ASSESSMENT REPORT

ORICA SOUTHLANDS PROJECT – BOTANY INDUSTRIAL ESTATE MP 06_0191 MOD 3

(b) As-Con with Turning Head at RL~3.85m (Scenario 1) - As Constructed

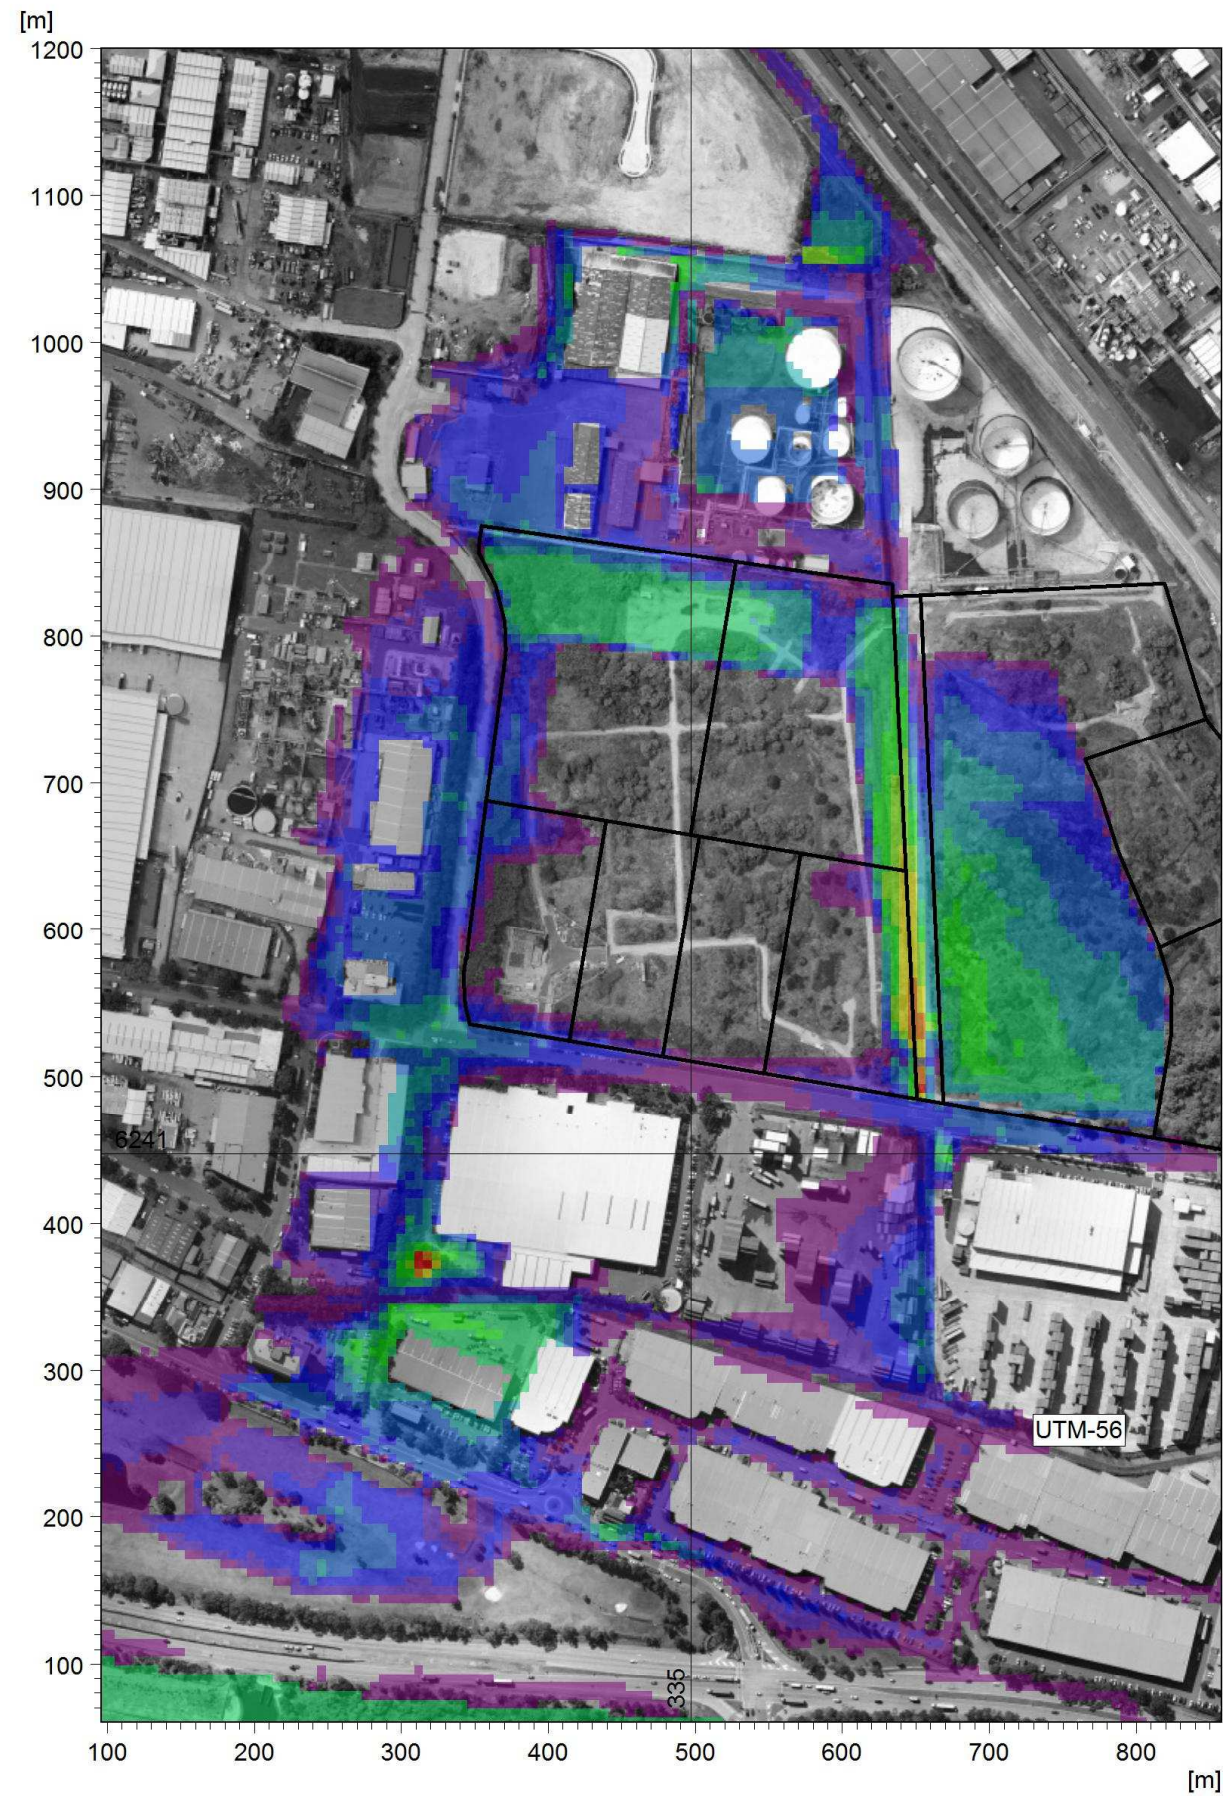
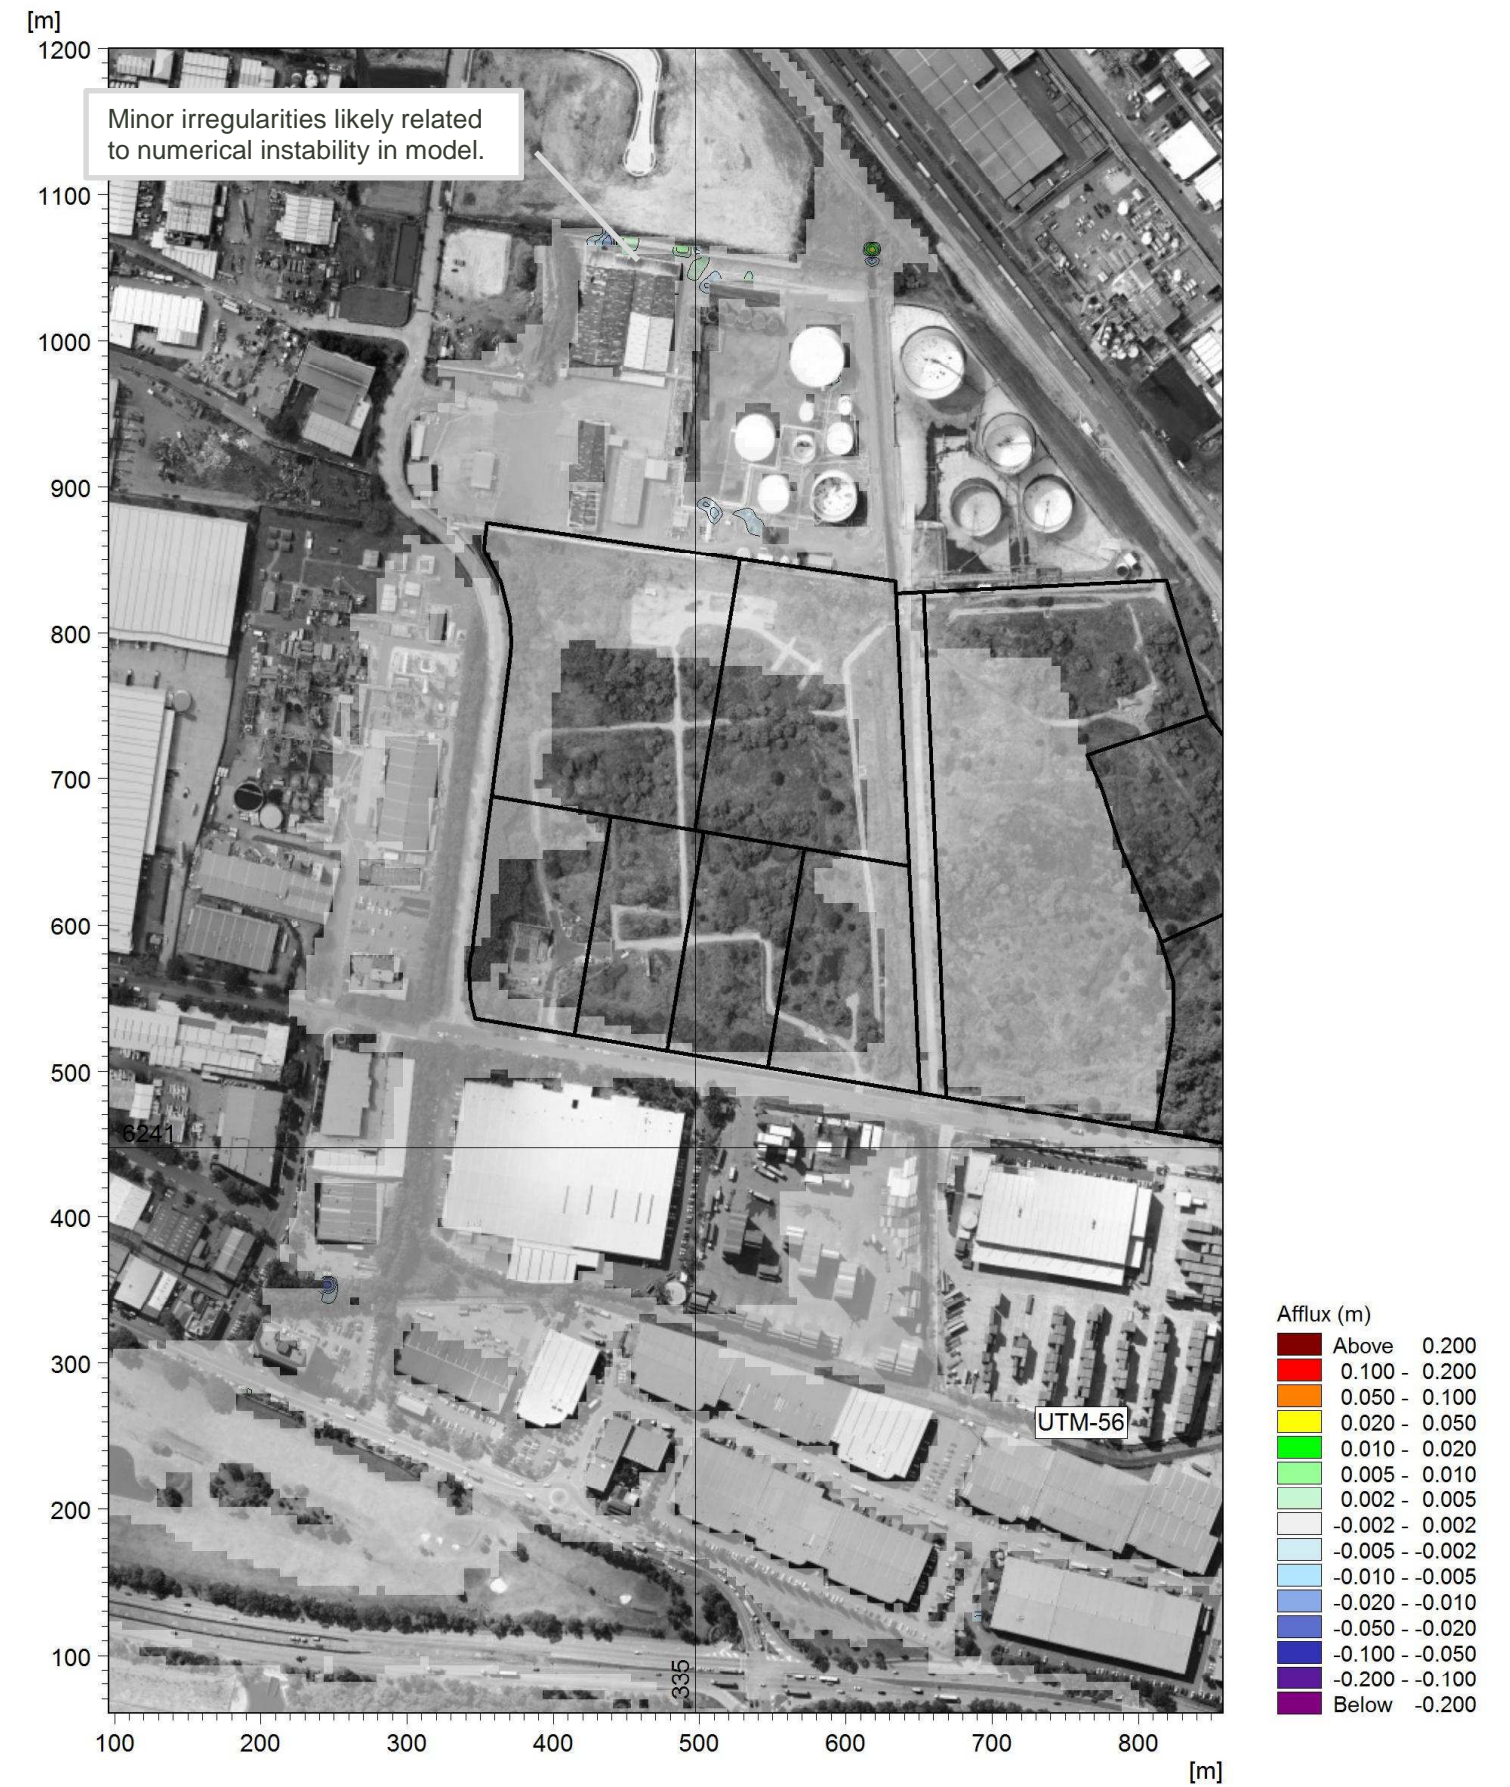
Following the submission of the Response to Submissions (RTS), Council advised it had one remaining concern, regarding the proposed height of the turning circle, noting that it is currently proposed at a level of RL 3.8 metres which is below the 1:100 year flood level. Council requested a condition be inserted to raise the level to RL 4.0 metres.

Council also raised concern with the level of the turning circle which varies between RL 3.8 metres and RL 4.6 metres. Council were concerned that the turning circle would not provide flood free access for emergency vehicles if it is constructed below RL 4.0 metres and requested a condition be incorporated which requires the finished level of the turning circle to be above RL 4.0 metres.

The peer review endorsed the proposed height of the turning circle for emergency vehicle access noting that:

- raising the level would result in additional and unacceptable increases in the flood level;
- the turning circle is proposed to service fire and rescue vehicles, and the likelihood of a coincident flood and fire event occurring is very rare; and
- flood depth warning signs would be provided so drivers can make an informed decision about whether to use the turning circle.

The Department is also of the view that the height of the turning circle is acceptable for emergency vehicle access at a height of RL 3.80 metres on the basis that:

- an increase in height would potentially cause unacceptable flood level increases;
- the probability of a fire at the time of a 1:100 year flood event is rare;
- flood depth warning signs would be provided, allowing fire services to make an informed decision regarding the use of the turning circle during a flood event; and
- emergency vehicles would still have access to the site during a flood event as fire trucks

are designed to traverse low level flood waters, and there is sufficient space in the car park to execute a three point turn without the need of the turning circle.
